ENGINEERING & TECHNOLOGY PRECINCT (ETP) REDEVELOPMENT – PHASE 1

DESIGN EXCELLENCE REVIEW PANEL (DERP) - MEETING No. 4

31 August 2018, 10.00am – 12.00pm

University of Sydney Engineering and Technology Precinct - Stage 1

Ground Plane Constellation of Spaces

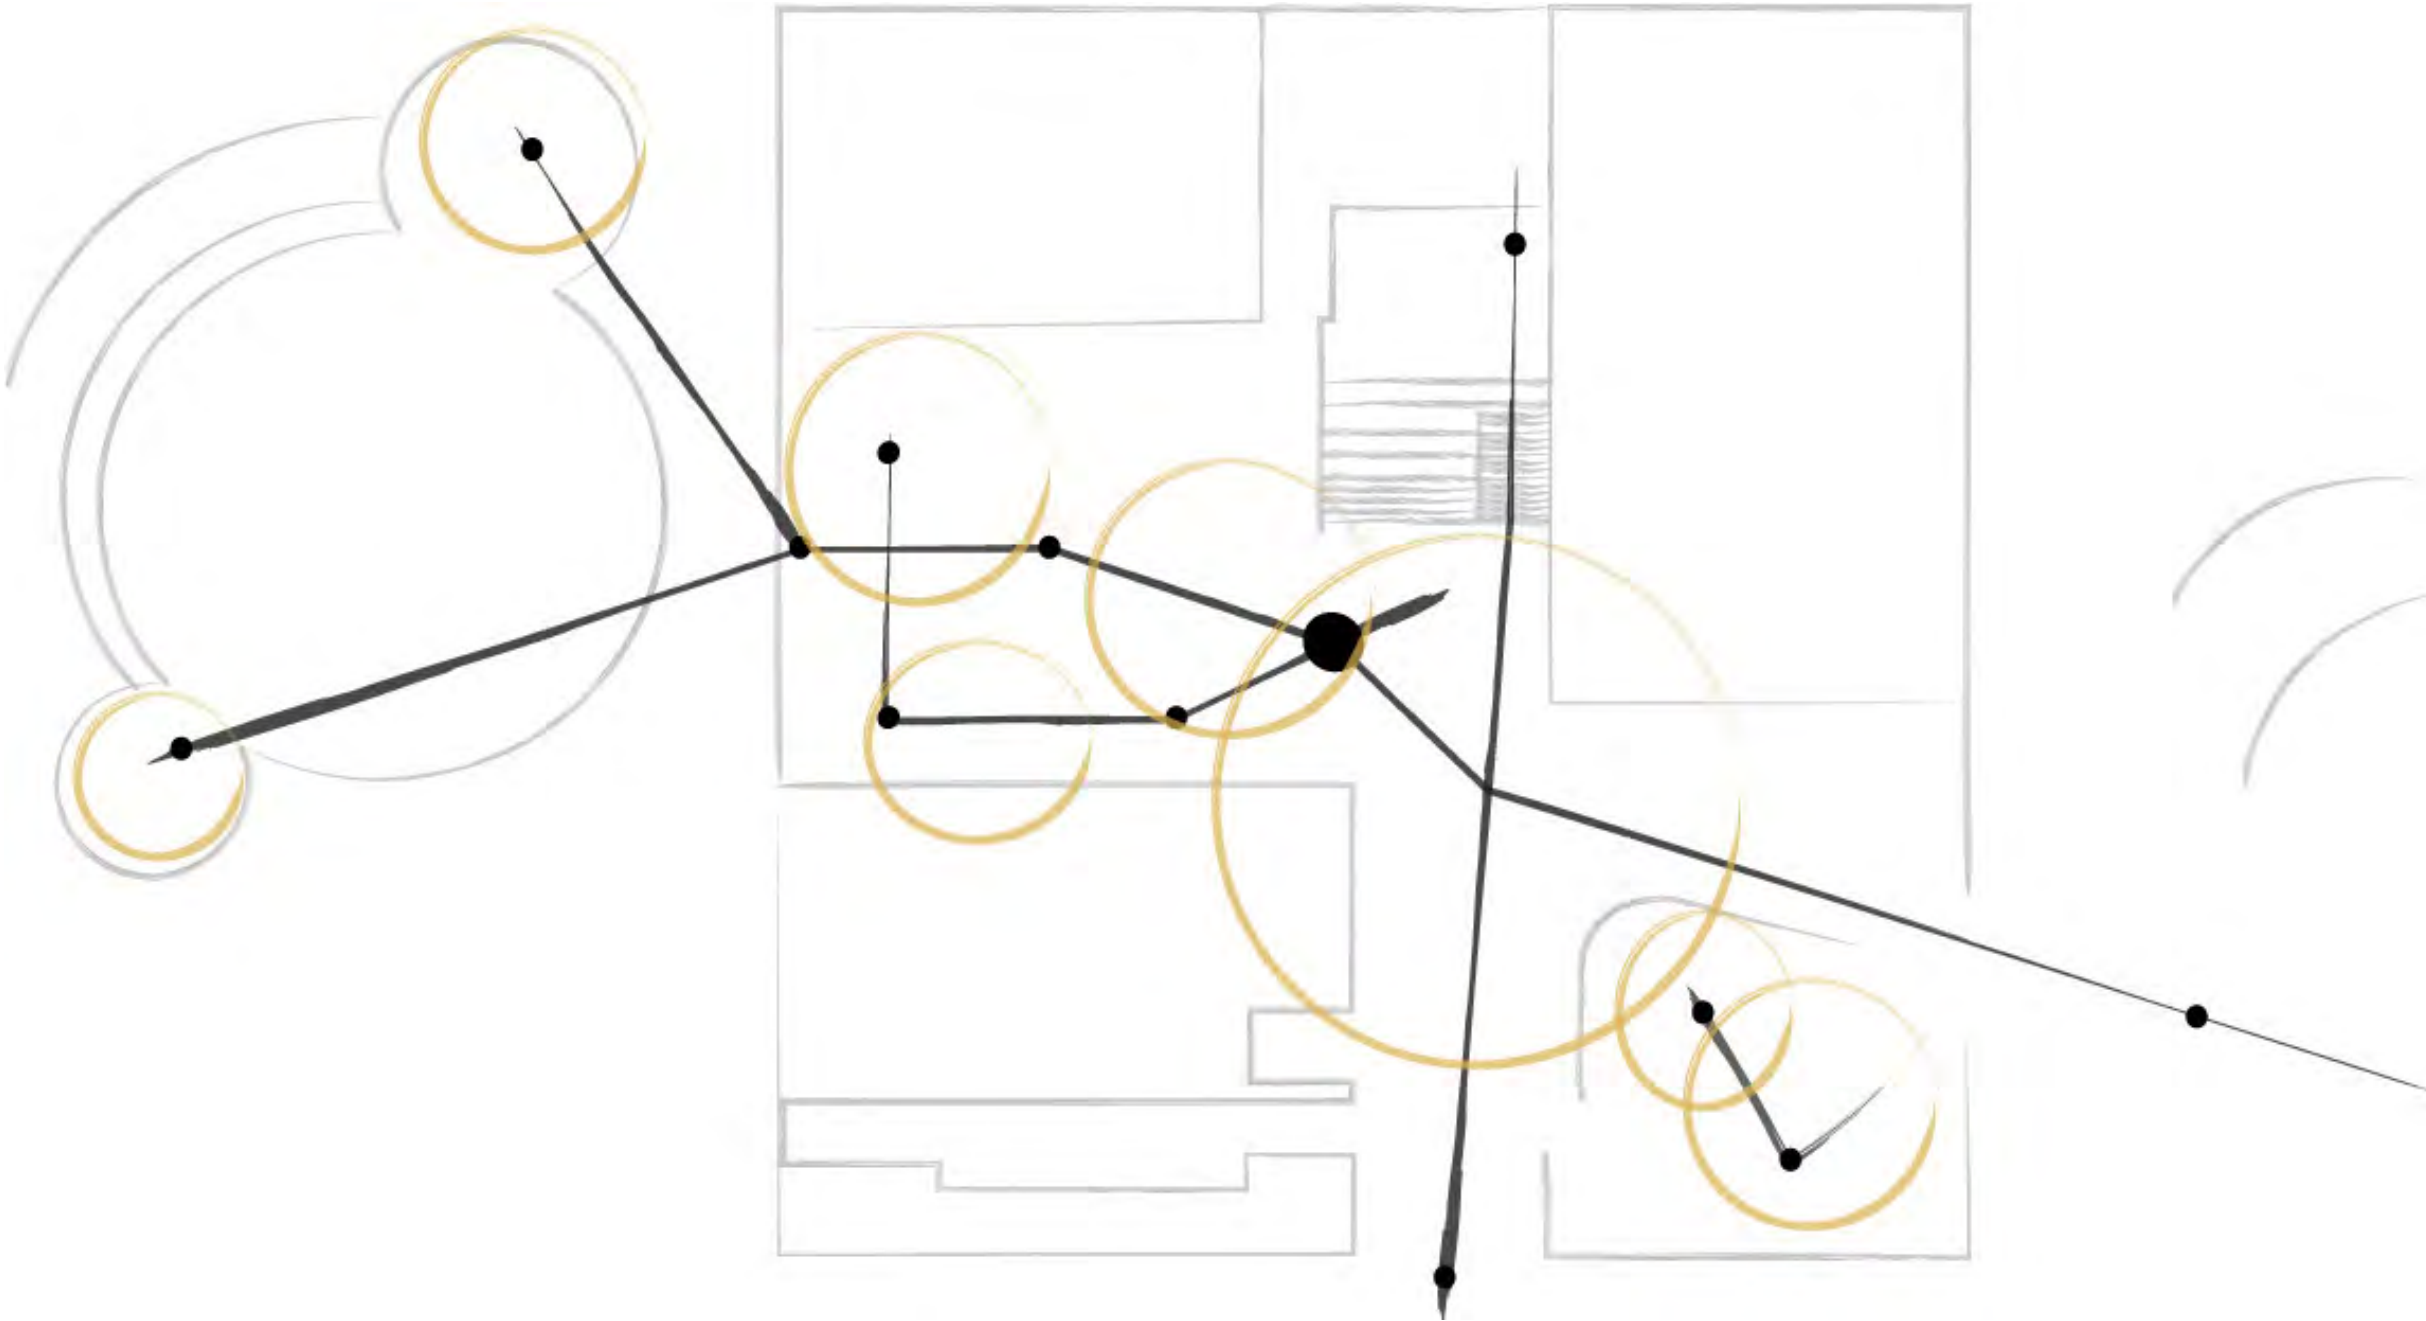
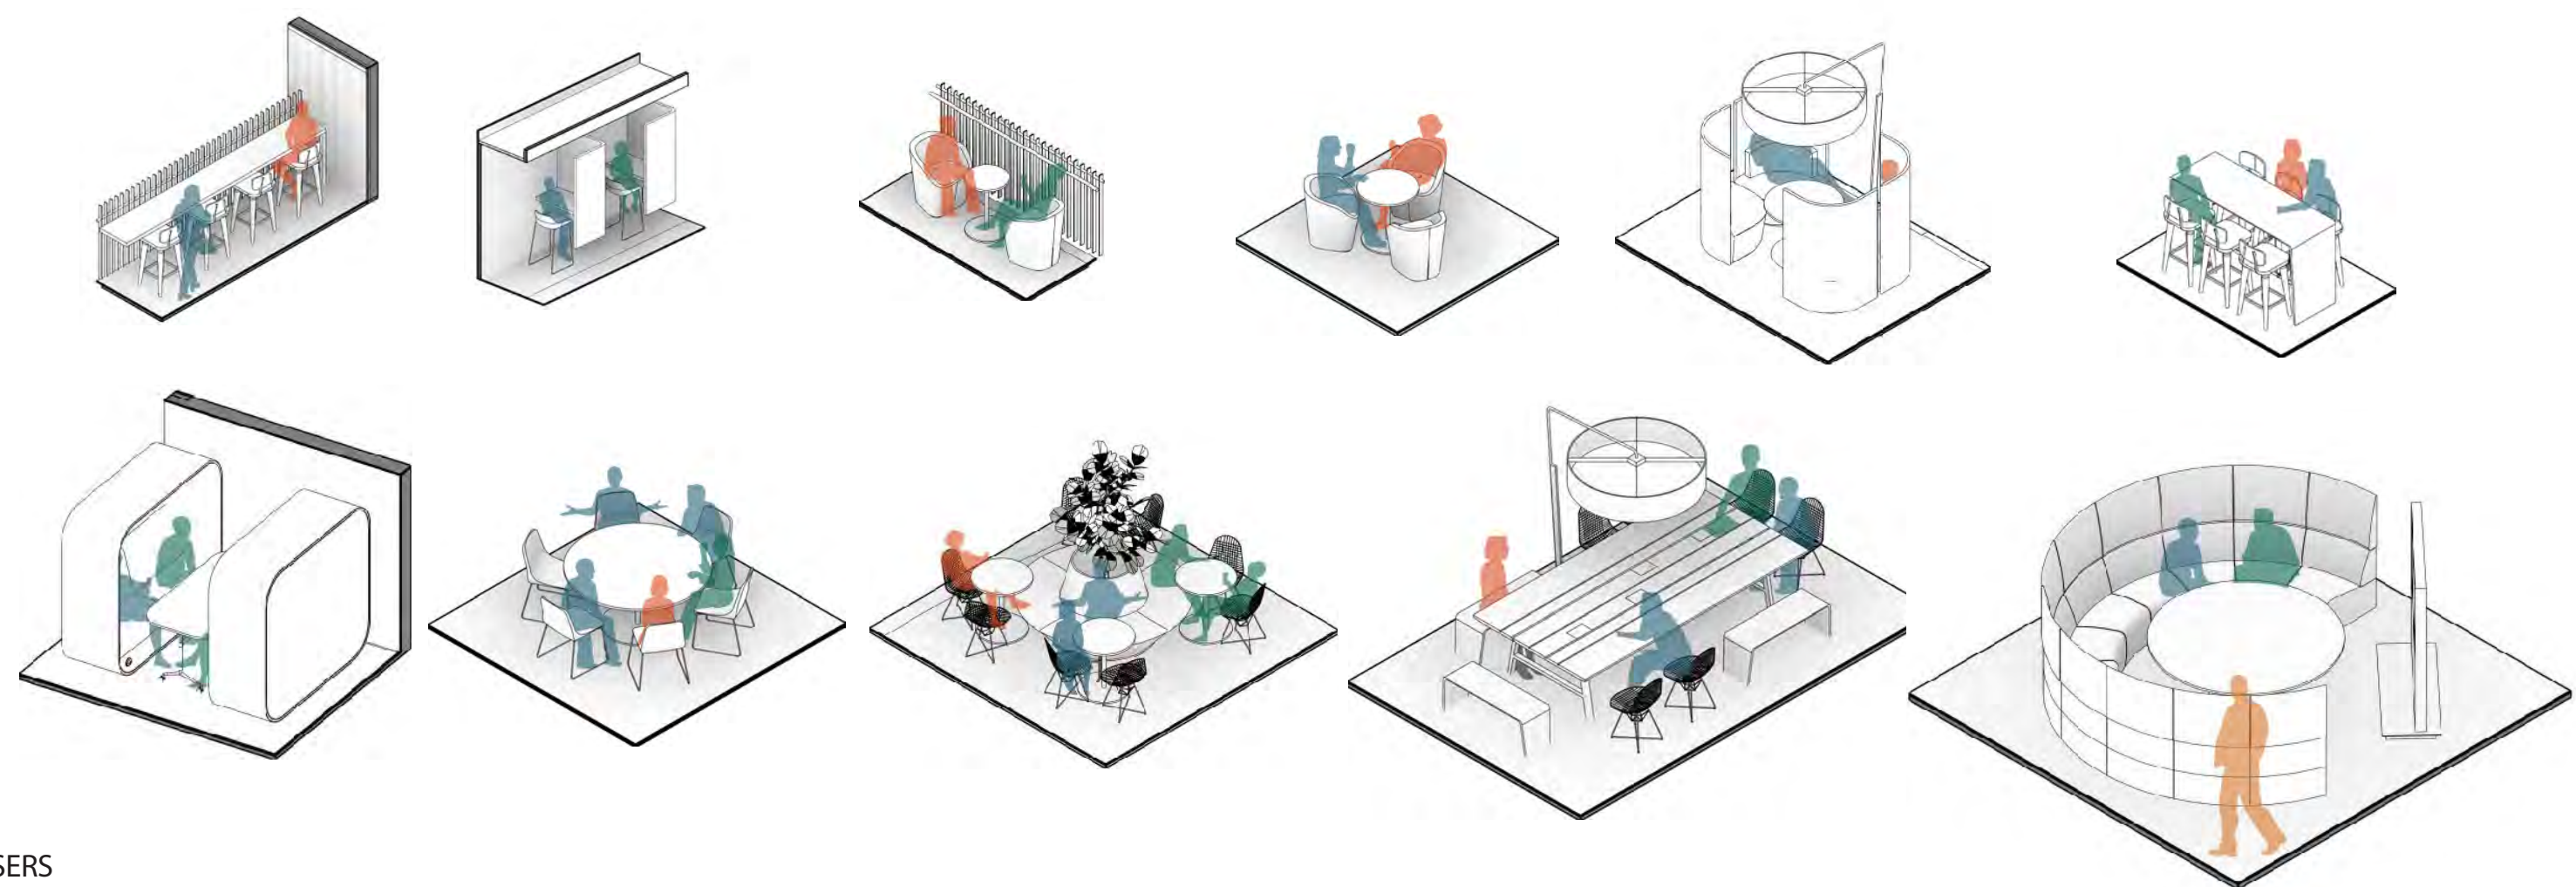
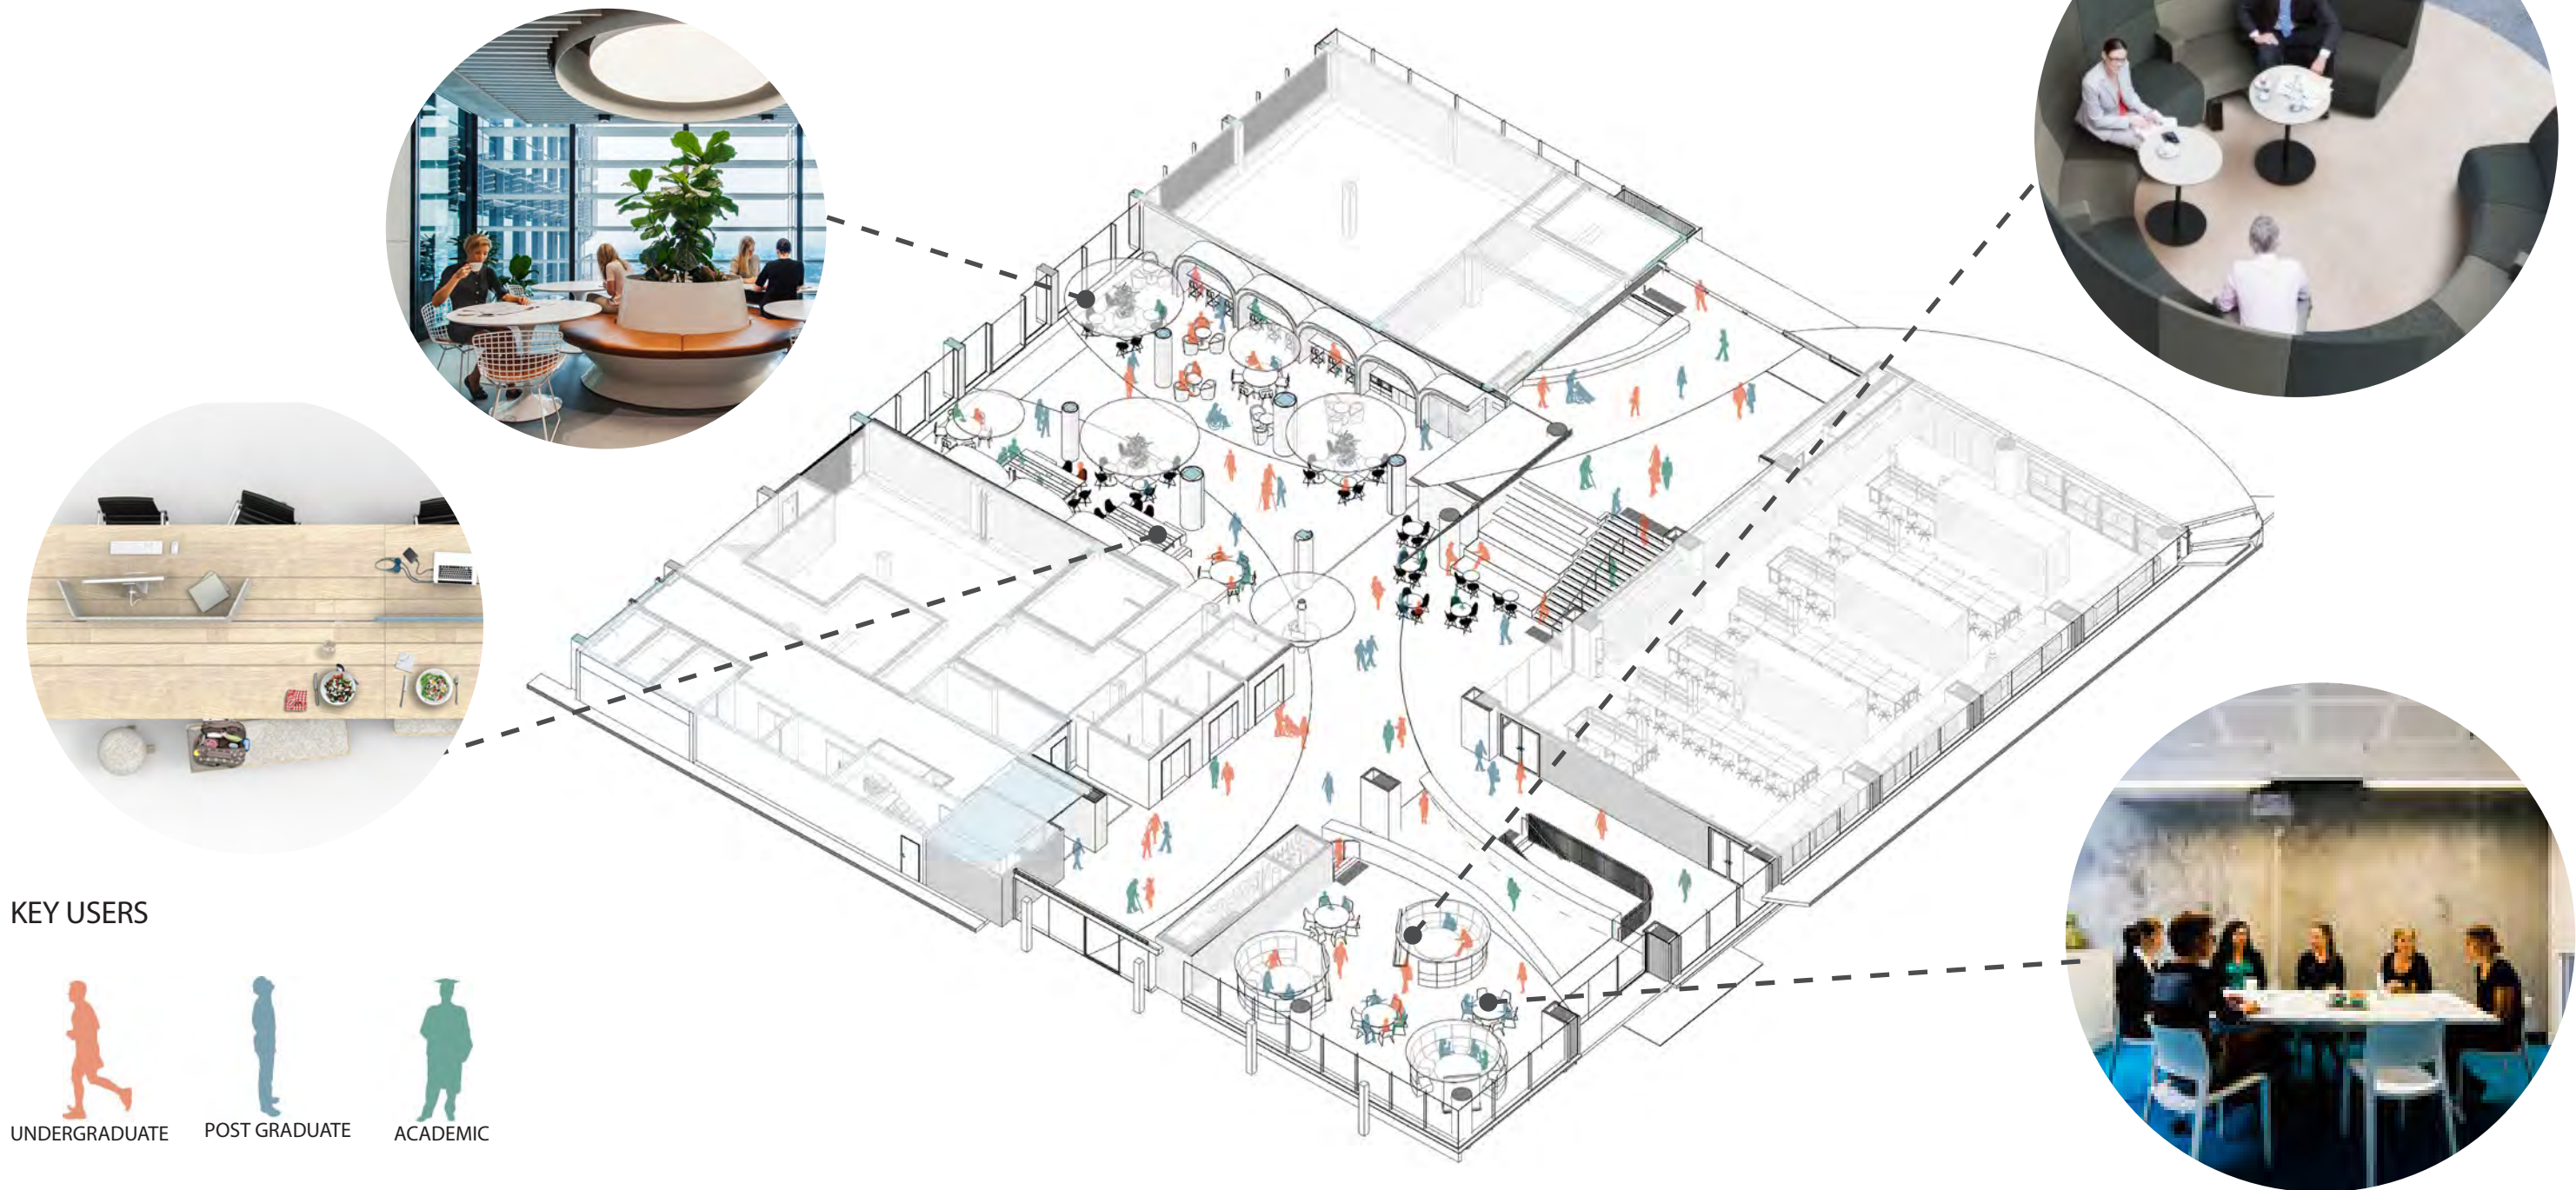
4. Clarification of northern areas as two distinct 'destinational spaces', rather than being given over too much to circulation	<ul style="list-style-type: none"> Refer to sheets 21 to 32. Constellation of spaces External casual spaces Teaching and Learning Spaces Performance and celebration spaces Culturally safe 	Generally acceptable to DERC. Destinational and circulatory spaces are mediated by curvilinear shapes integrated into the floor, which extend the astronomy patterns of the landscape design into the interior. While this is supported, a less singular, hard-edge line in the paving pattern would be preferable (as incorporated into the existing pathways of Cadigal Green).

5. Variety in scale of gathering spaces to be developed.	<ul style="list-style-type: none"> Refer to sheets 21 to 32. Refer to comments on point 4 above. Softened the hard landscaping by creating destinational landscapes with more lawn space, low walls for seating and gathering, using circular forms for amphitheatre for teaching/study groups/ small events. 	Generally acceptable to DERC. Refer to comment on point 4 above.
